CITY OF PORTLAND BUILDING PERMIT

Job ID: 2011-08-2127-ALTR

has permission for after-the-fact construction of a 27.5 by 10 foot deck with steps, provided that the person or persons, firm or corporation accepting this permit shall comply with all of the provisions of the Statutes of Maine and of the Ordinances of the City of Portland regulating the construction, maintenance and use of the buildings and structures, and of the application on file in the department.

WILLIAMS DECK
 224 PLEASANT AVENUE
 PEAKS ISLAND, MAINE

Deck Plan

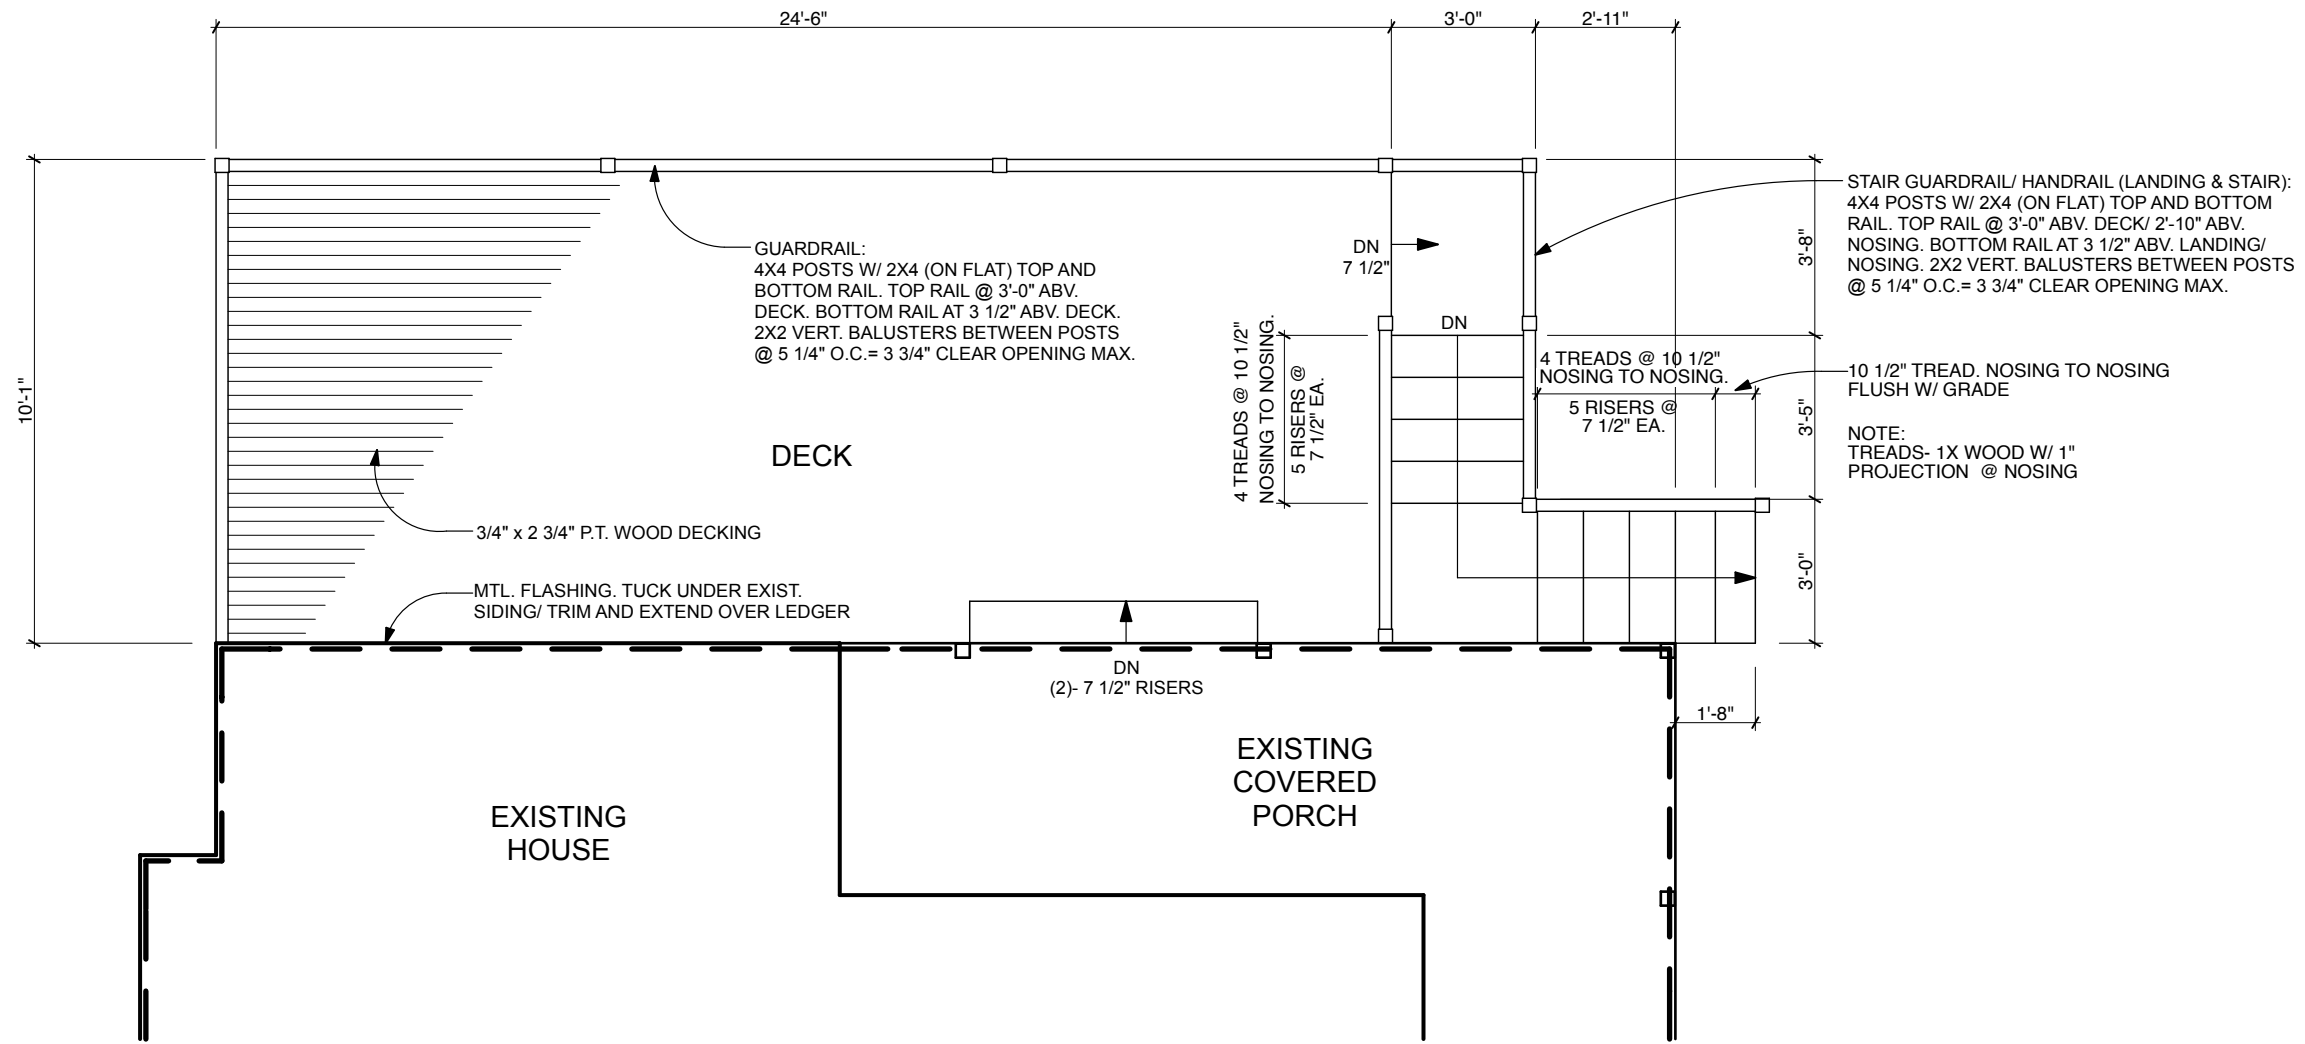
4. R312.3 Opening limitations. Required *guards* shall not have openings from the walking surface to the required *guard* height which allow passage of a sphere 4 inches in diameter.

5. R311.5.1 Attachment. Exterior landings, decks, balconies, stairs and similar facilities shall be positively anchored to the primary structure to resist both vertical and lateral forces or shall be designed to be self-supporting. Attachment shall not be accomplished by use of toenails or nails subject to withdrawal.

Deck Foundation Plan

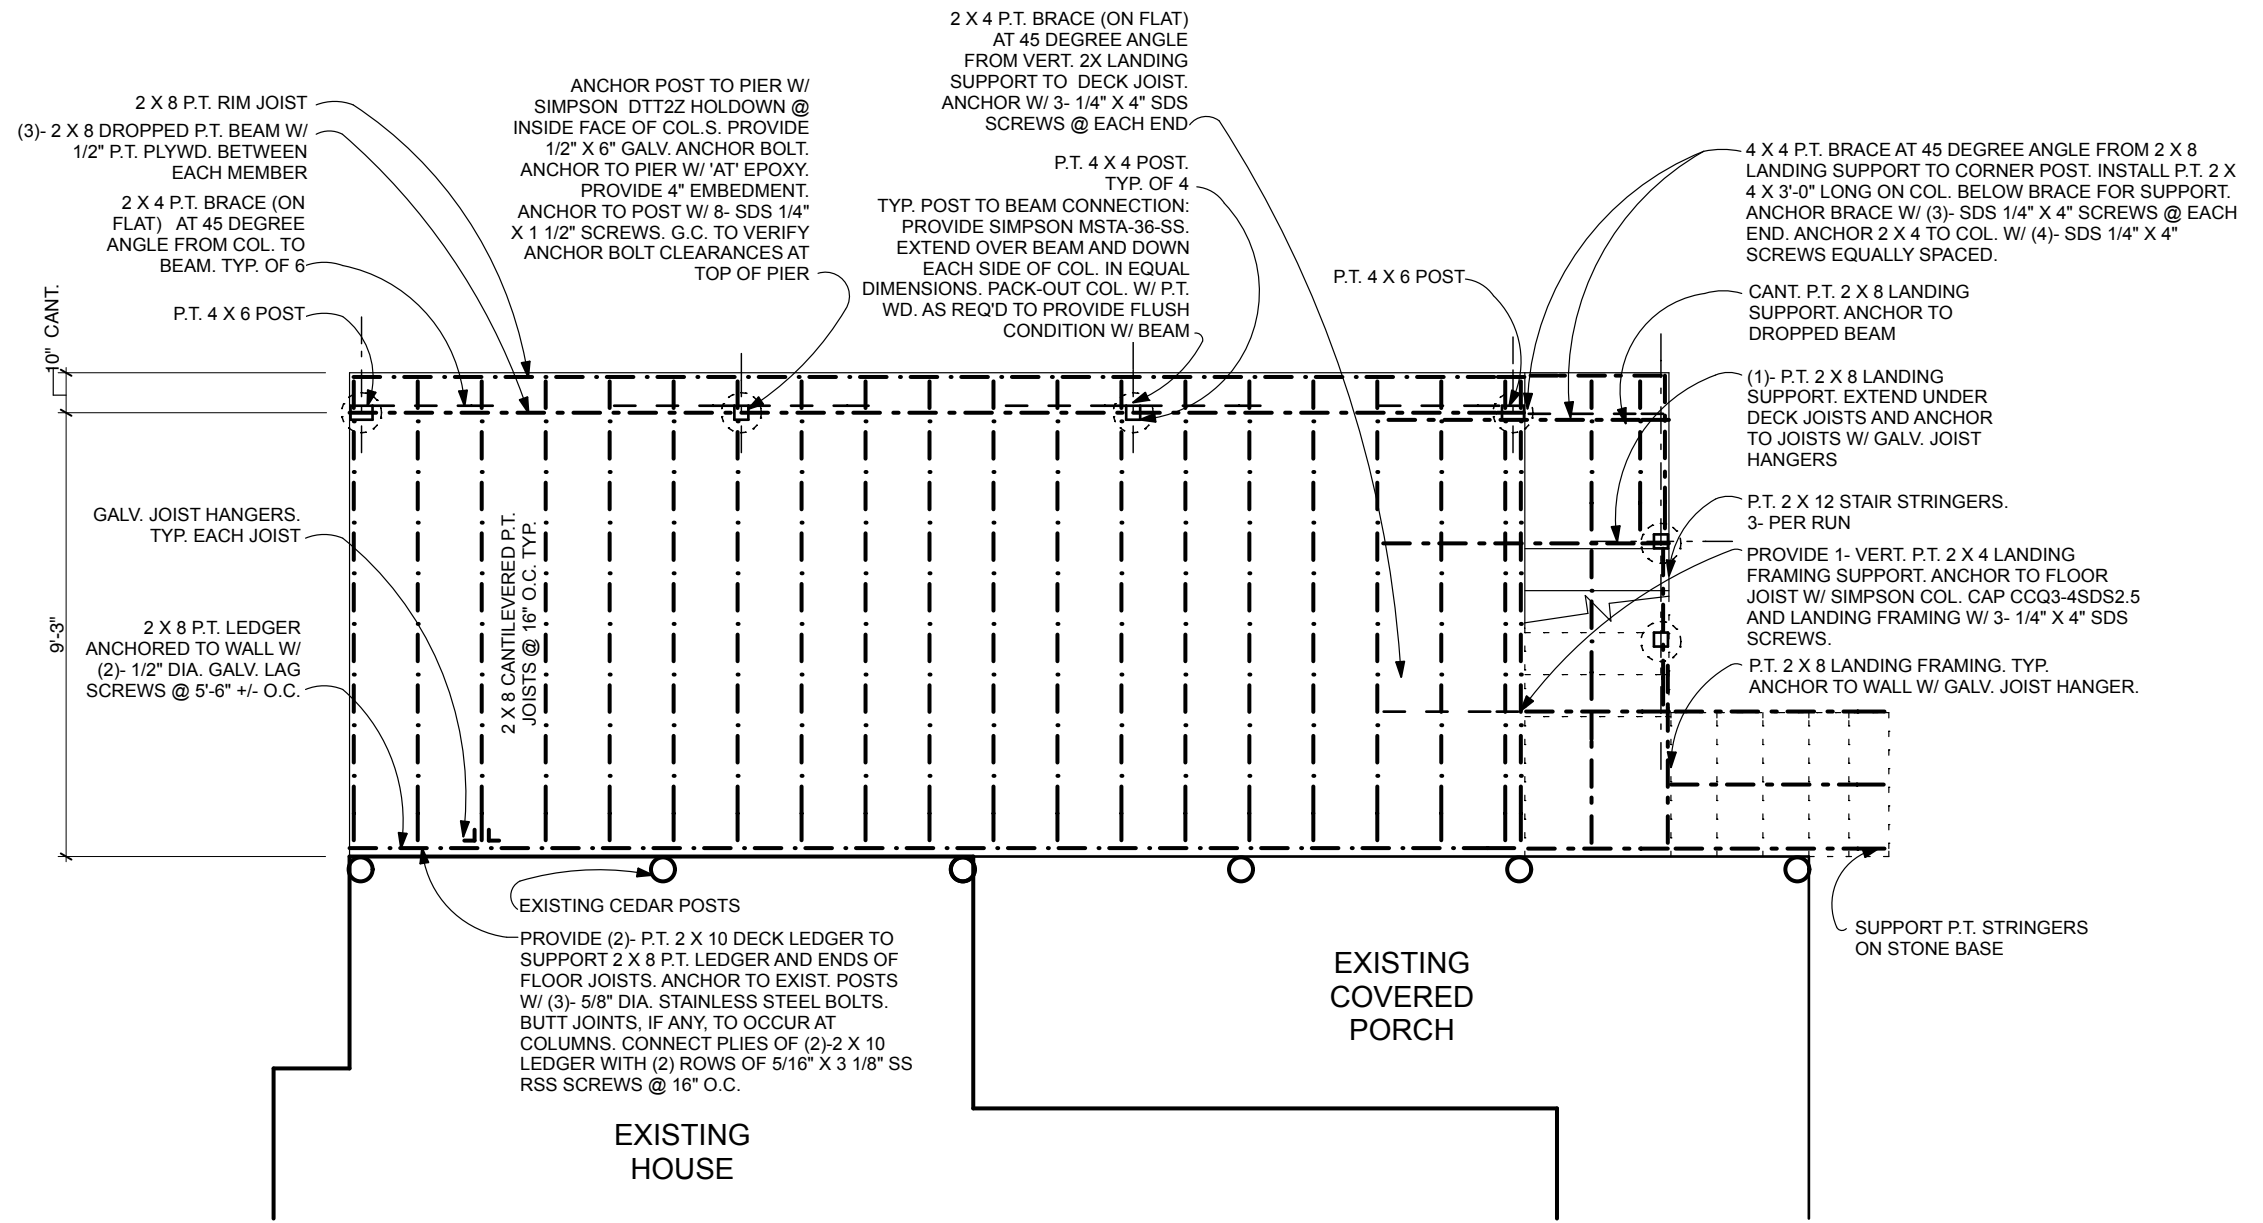
2. Frost protection must be installed per the enclosed detail as discussed w/owner/contractor (at least 4' from grade).
3. A graspable handrail (34-38 inches in height) shall be provided on at least one side of each continuous run of treads or flight with four or more risers. Fall protection (36 inches) from exterior decks may be required if floor joist are at or above thirty (30) inches from grade.

7. Note: Contractor will utilize two (2) 2 X 10 inch P.T. SPF # 2 beams with a max span of 8 foot 5 inch, possibly posting down on the house side (if ledger connection is not verified). Cantilever landing will be supported by a beam and posted down to grade with frost protection.
